Our Ref: HM/7385

Proposal: 14/02004/HYBRID | OUTLINE:- Up to 1500 dwellings, including affordable housing and up to a 150 unit care village (C2) with associated publicly accessible ancillary facilities; site for a new primary school; up to 930sqm of retail space; up to 7,500sqm locally led employment (B1/B2/B8) including link and ride; site for a football association step 5 football facility with publicly accessible ancillary facilities; public open space, associated infrastructure, engineering and ancillary works, (all matters reserved except for means of access to the development); and Full Planning:- development of Phase 1 at the south western corner of the site for the erection of 29 residential dwellings (29 or the 1500 described above) with associated open space, parking and landscaping; with vehicular access provided from Upper Campsfield Road (A4095), Shipton Road and Oxford Road (A44) | Land South Of Perdiswell Farm Shipton Road Shipton On Cherwell

I have been instructed to write to you on behalf of Woodstock Town Council (WTC) to object to this application. In short the proposal is plainly contrary to national planning policy and policies within both West Oxfordshire's

JOB TITLE South East Woodstock		CLIENT Pye Homes	
DRAWING TITLE Marlborough School Coach Park			
SCALE 1/1250@A3	DRAWN BY BP	DATE Sept14	DRAWING No 15291-23
			REVISION

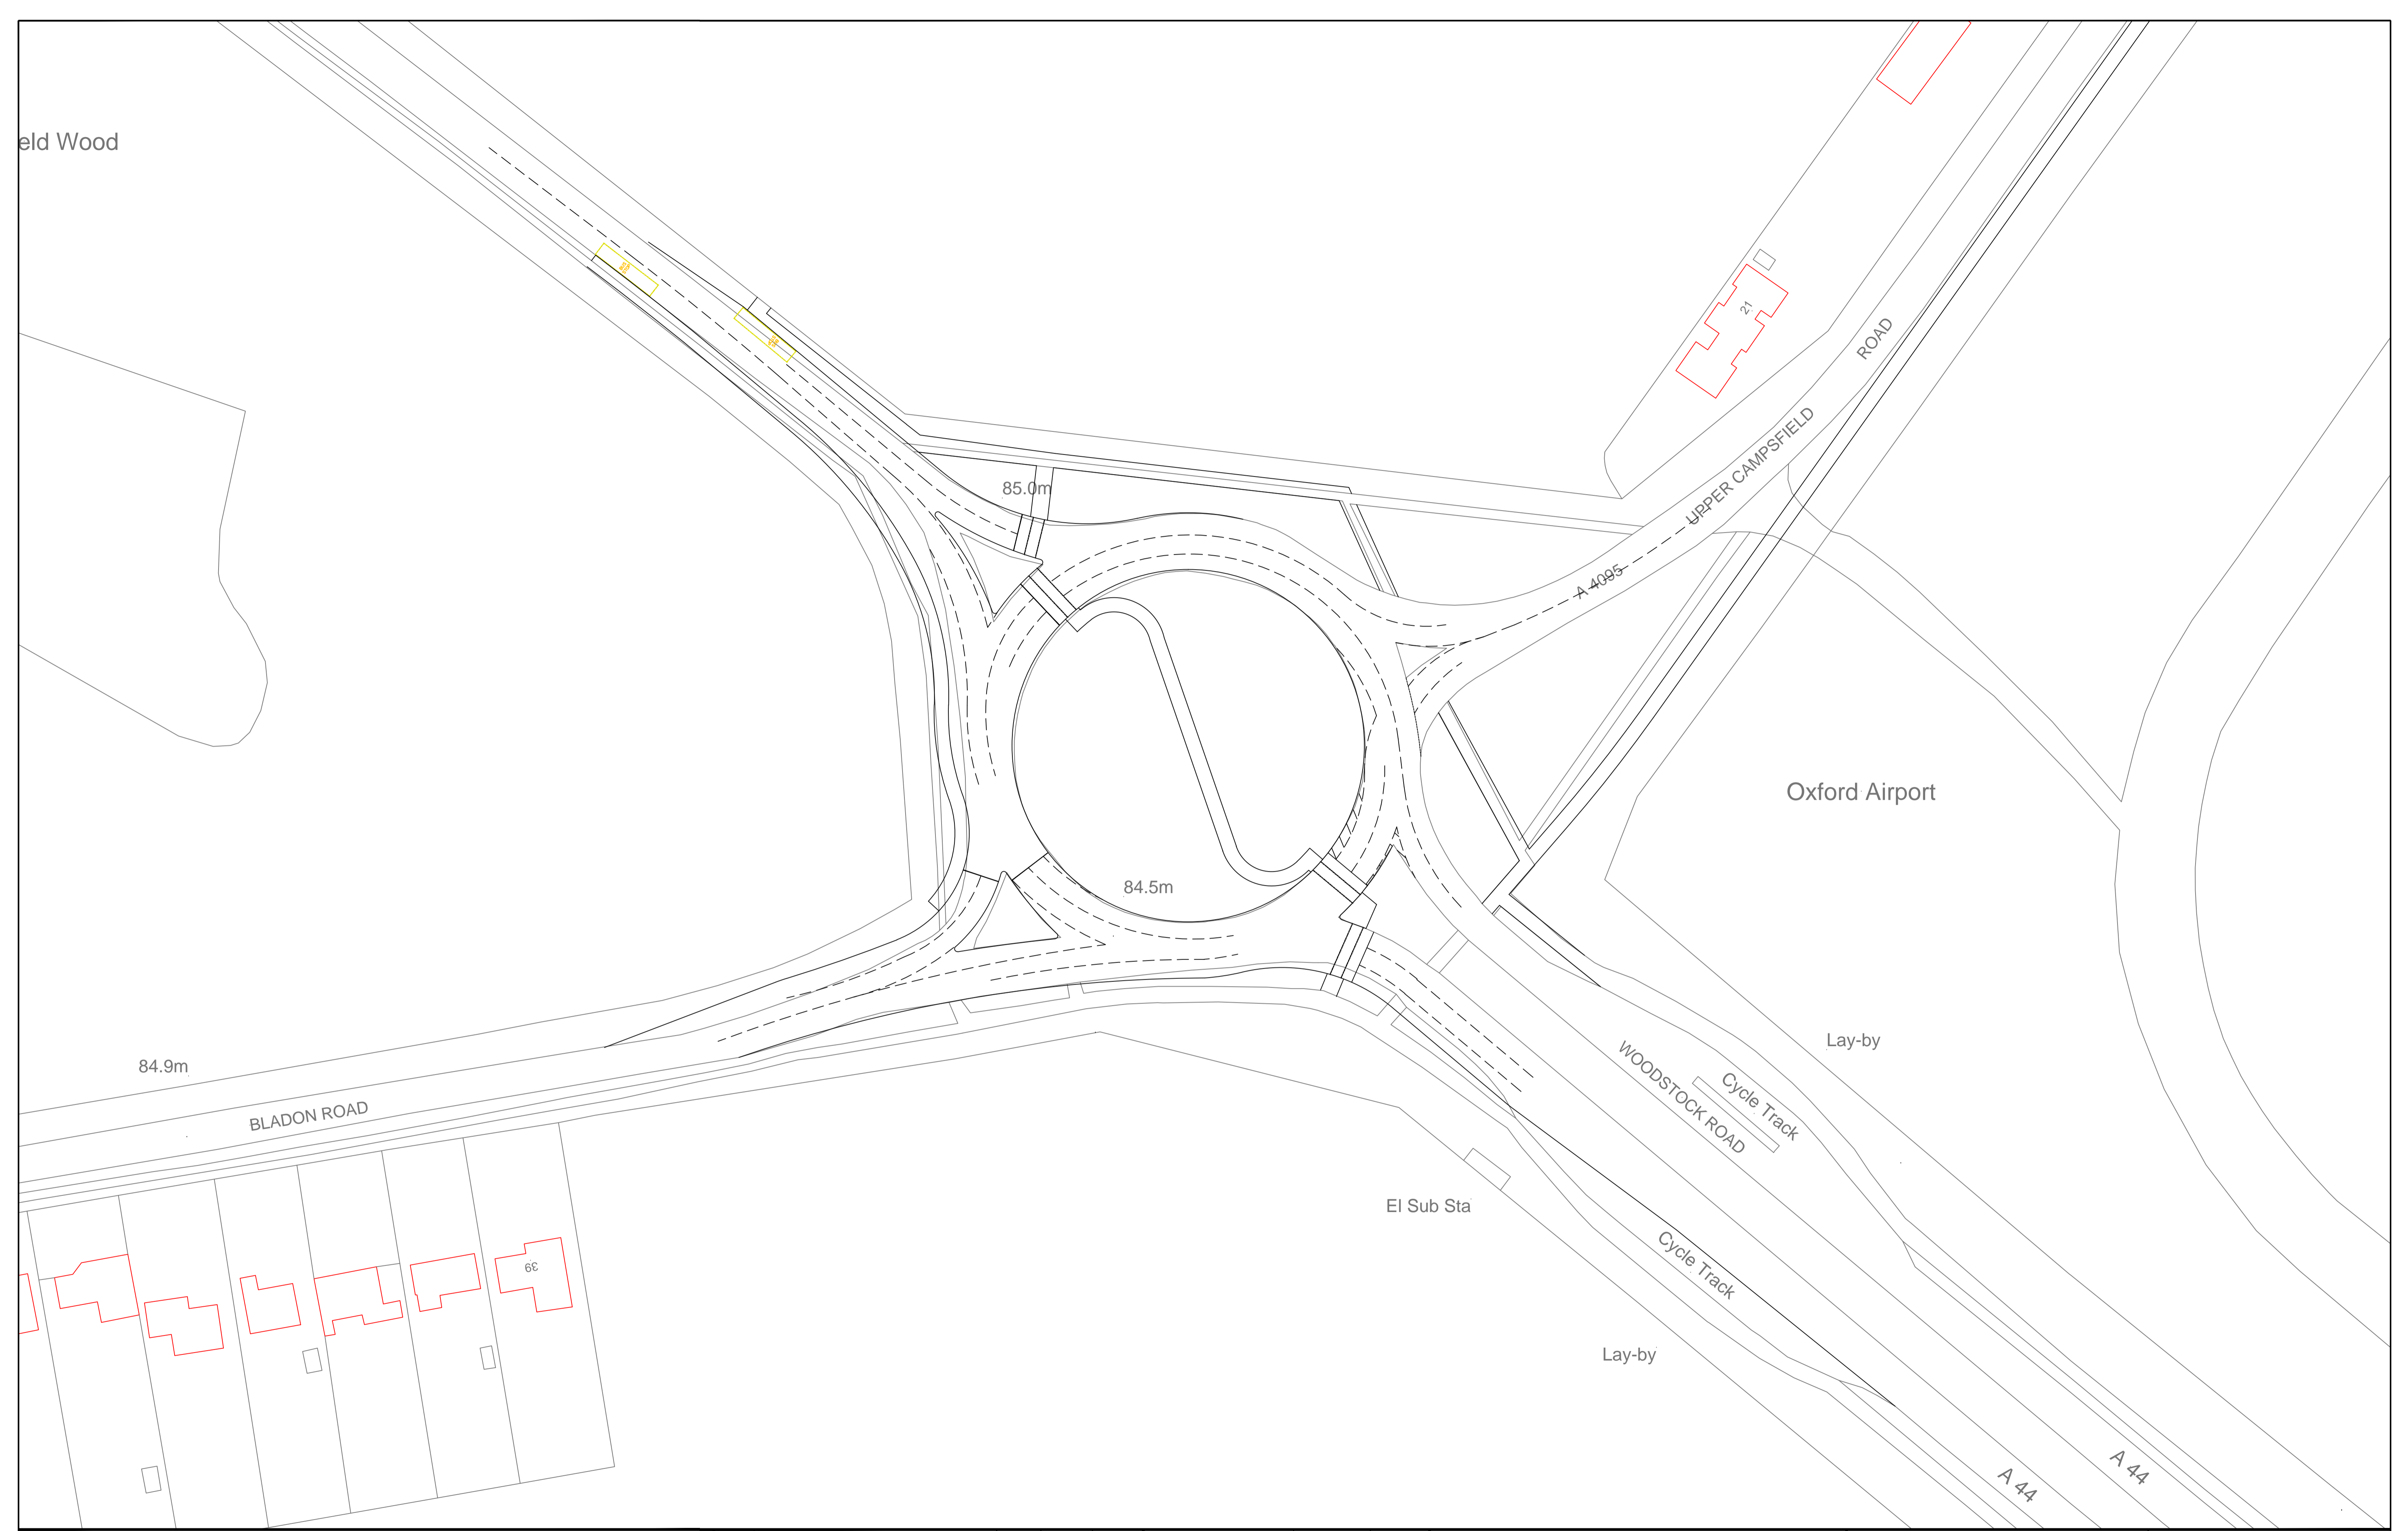
- The Marlborough School coach park and road alignment appear to require third party land – it is not clear whether this is available.
- TRICS trip rates used to generate traffic for all elements of the scheme are questionable where the sites and parameters used do not appear to provide entirely reasonable comparison in terms of size type and location to the proposed development.

JOB TITLE		South East Woodstock		CLIENT		Pye Homes & Vanbrugh Trust	
DRAWING TITLE							
Proposed Bladon Roundabout Improvement Works							
SCALE	DRAWN BY	DATE	DRAWING No	REVISION			
1:500@A1	BP	Oct14	15291-14	C

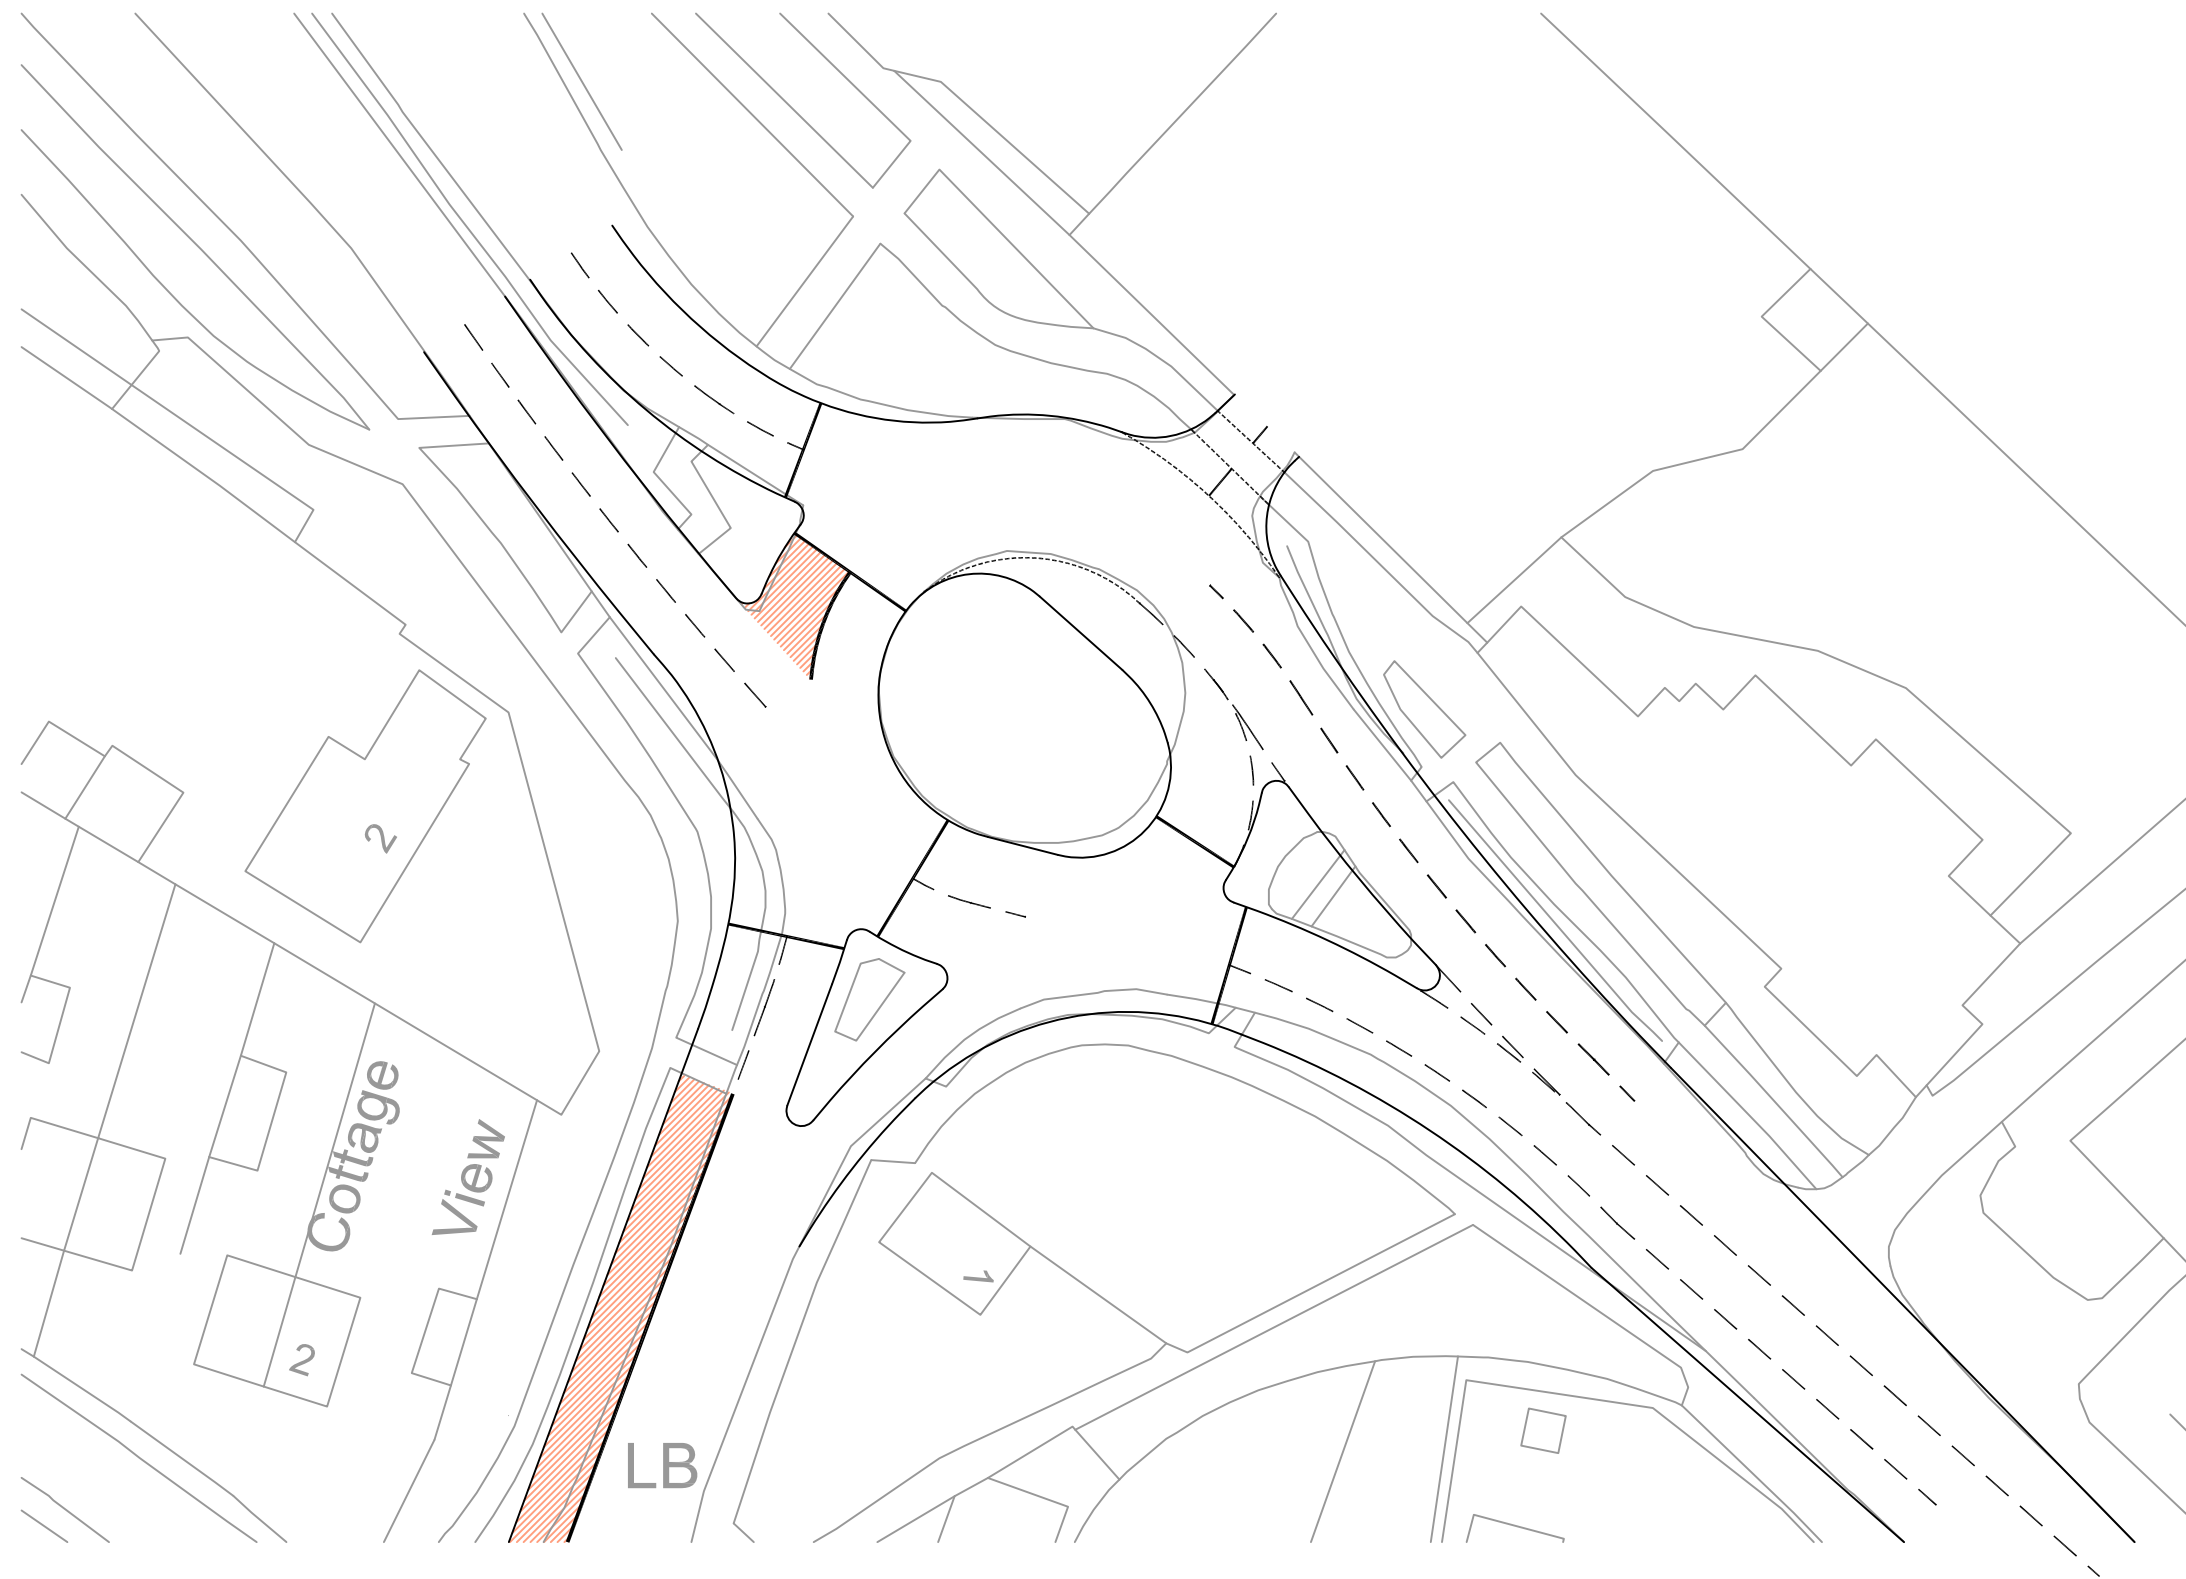
There are also real safety concerns over the proposed cycle path crossing the busy Bladon Roundabout, particularly if it is going to be used by children.
